From: Laura Gibbons <Laura.Gibbons@arun.gov.uk>
Sent: 26 October 2021 15:42
To: Planning.Responses <Planning.Responses@arun.gov.uk>
Cc: Simon Davis <Simon.Davis@arun.gov.uk>
Subject: RE: Planning Consultation on: BN/134/21/DOC

Application No: BN/134/21/DOC
Registered: 13th October 2021
Site Address: Land rear of 1 Northfields Cottage Fontwell Avenue Eastergate PO20 3RX
Description of Works: Approval of details reserved by condition imposed under BN/50/20/PL relating to conditions 10-surface water drainage, 11-maintenance & management of surface water drainage & 20-materials & finishes.

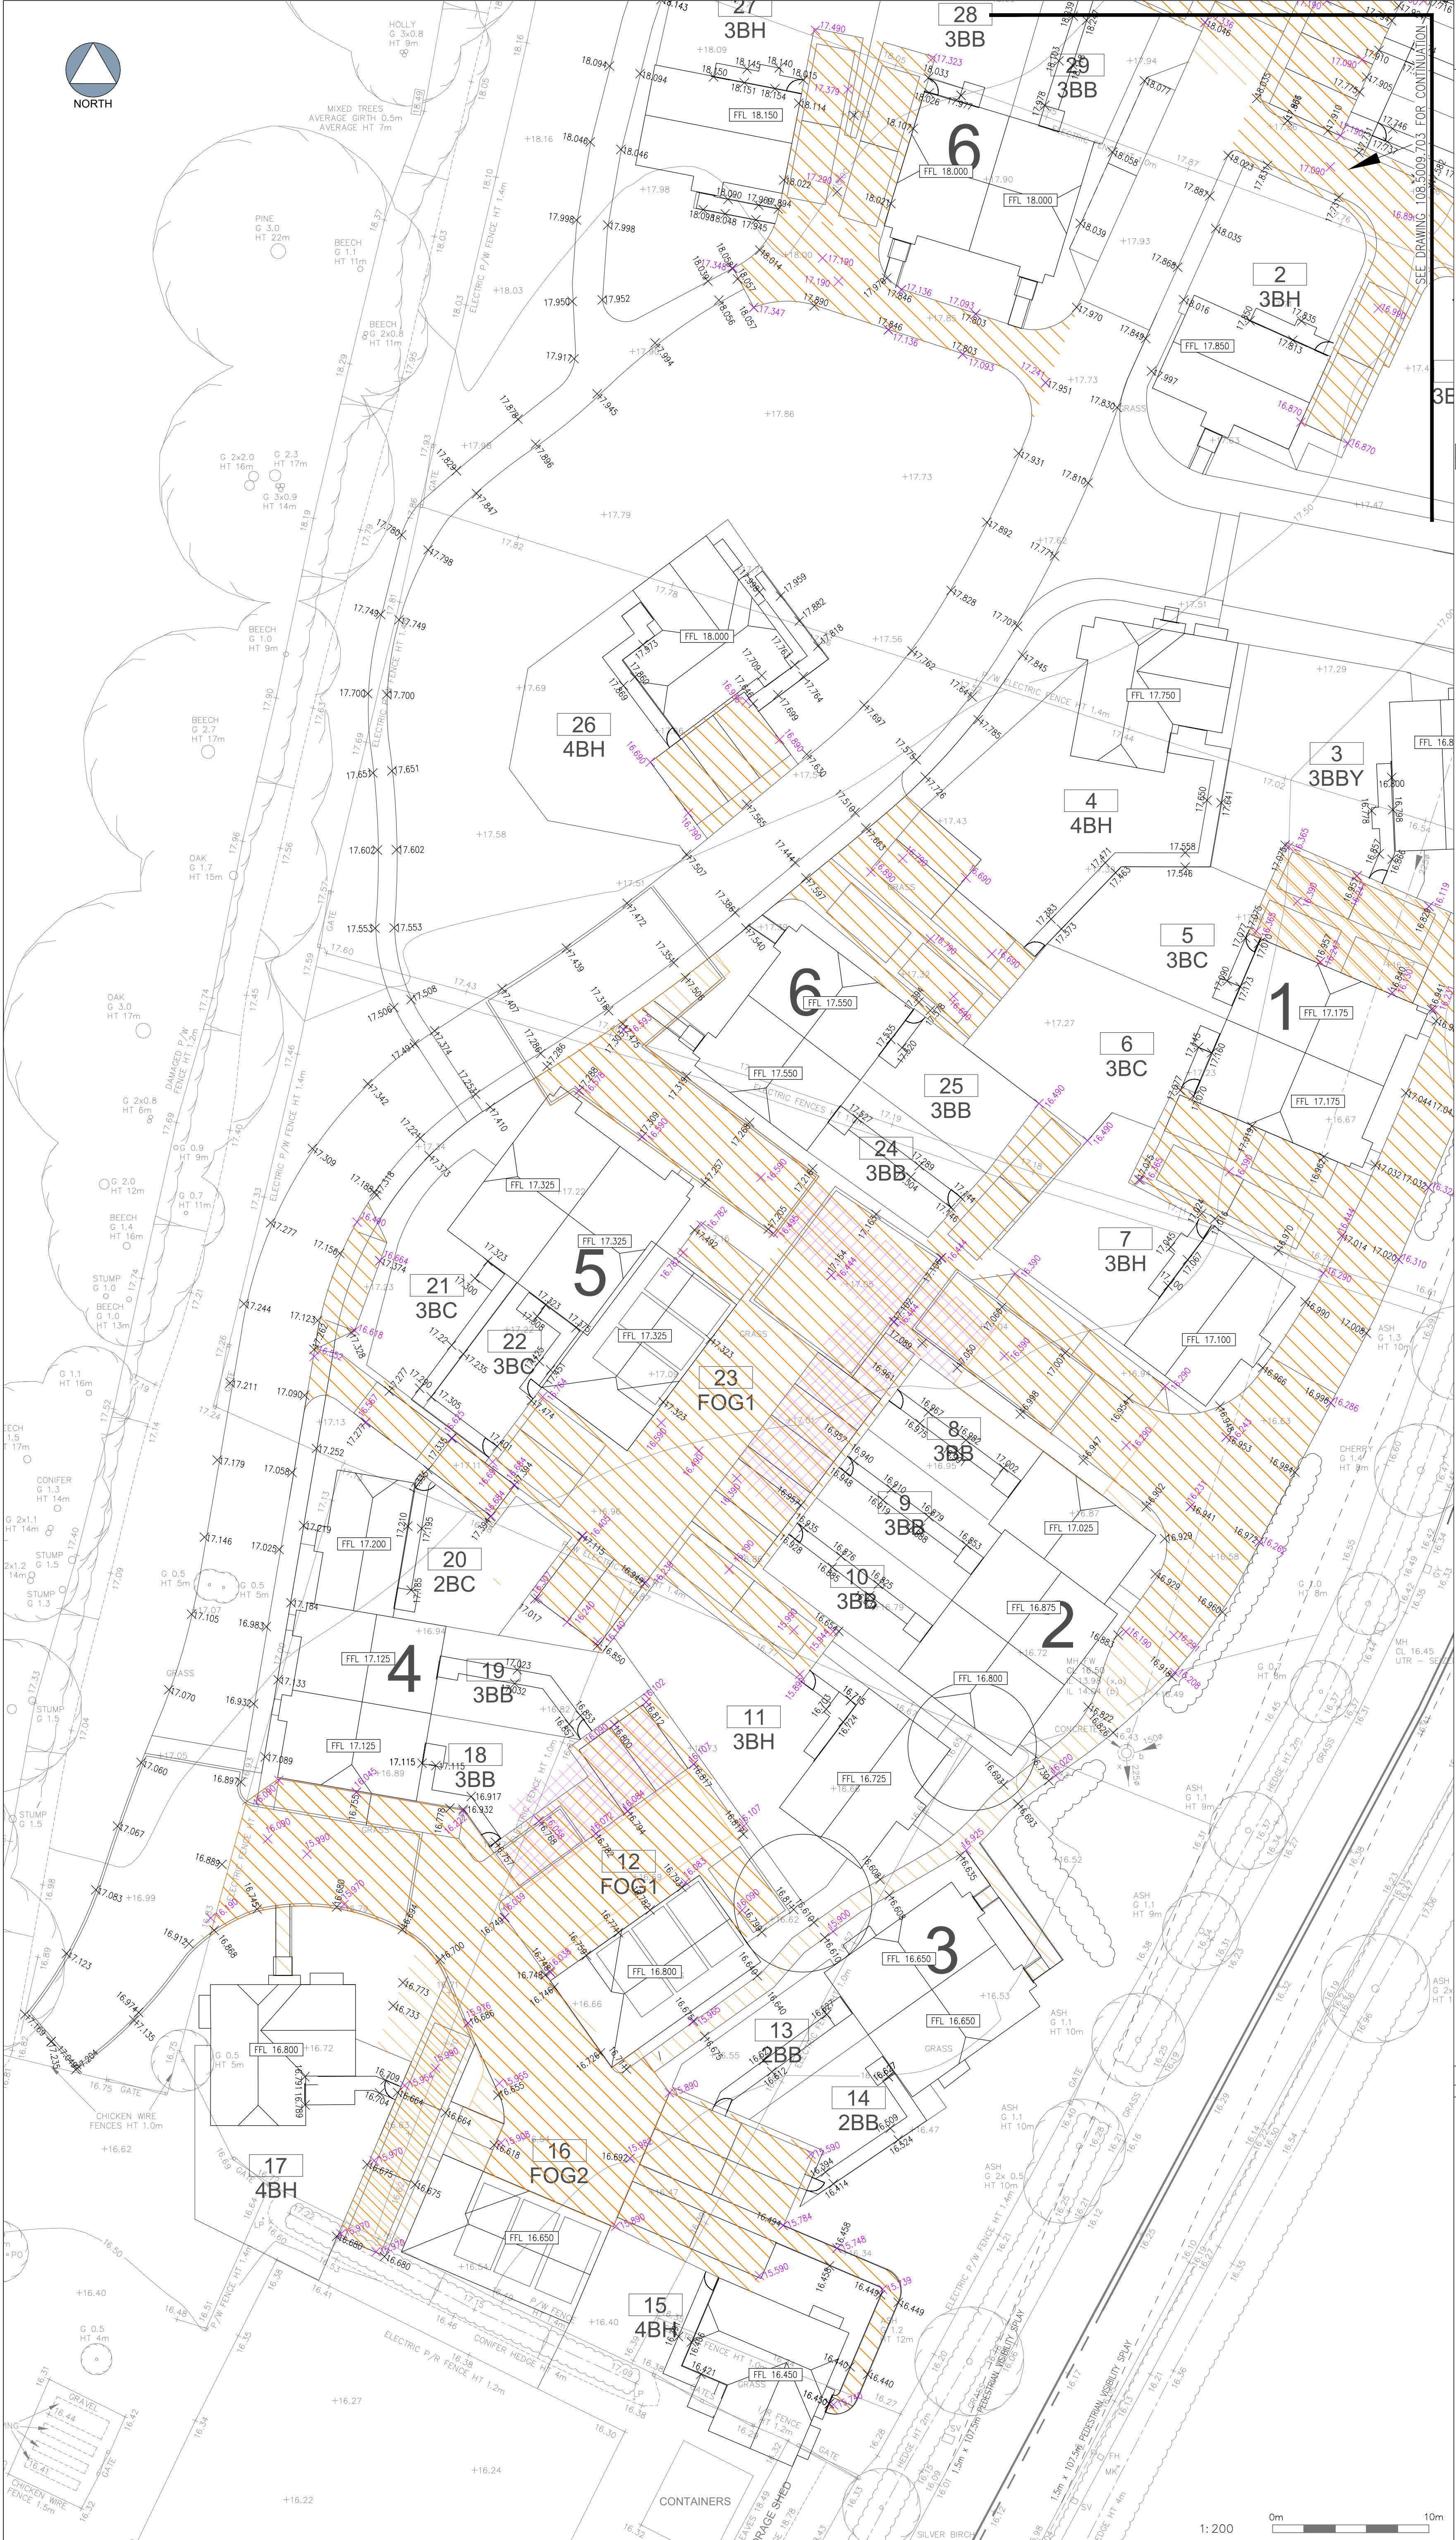
proposals for permeable paving sub-base near to plots 14-19 are okay without check dams/ baffles, there is 500mm difference in formation level over not that large a distance.

6. It appears there is a typo with the formation level near to plots 1 and 42. A formation level of 17.69 is stated, which is greater than the finish level.
7. Capping layer below type 3 on the permeable paving must state "no fines". Please also clearly label the base geotextile.
8. The soakaway construction detail needs to be improved. As crate depth varies, the detail should not state total 400mm thick, and should instead state that the depth varies and reference the plans that depth is detailed on. Minimum cover depth should be stated.
9. Please provide a construction detail drawing of granular soakaways.
10. Portsmouth water and the environment agency should be consulted.
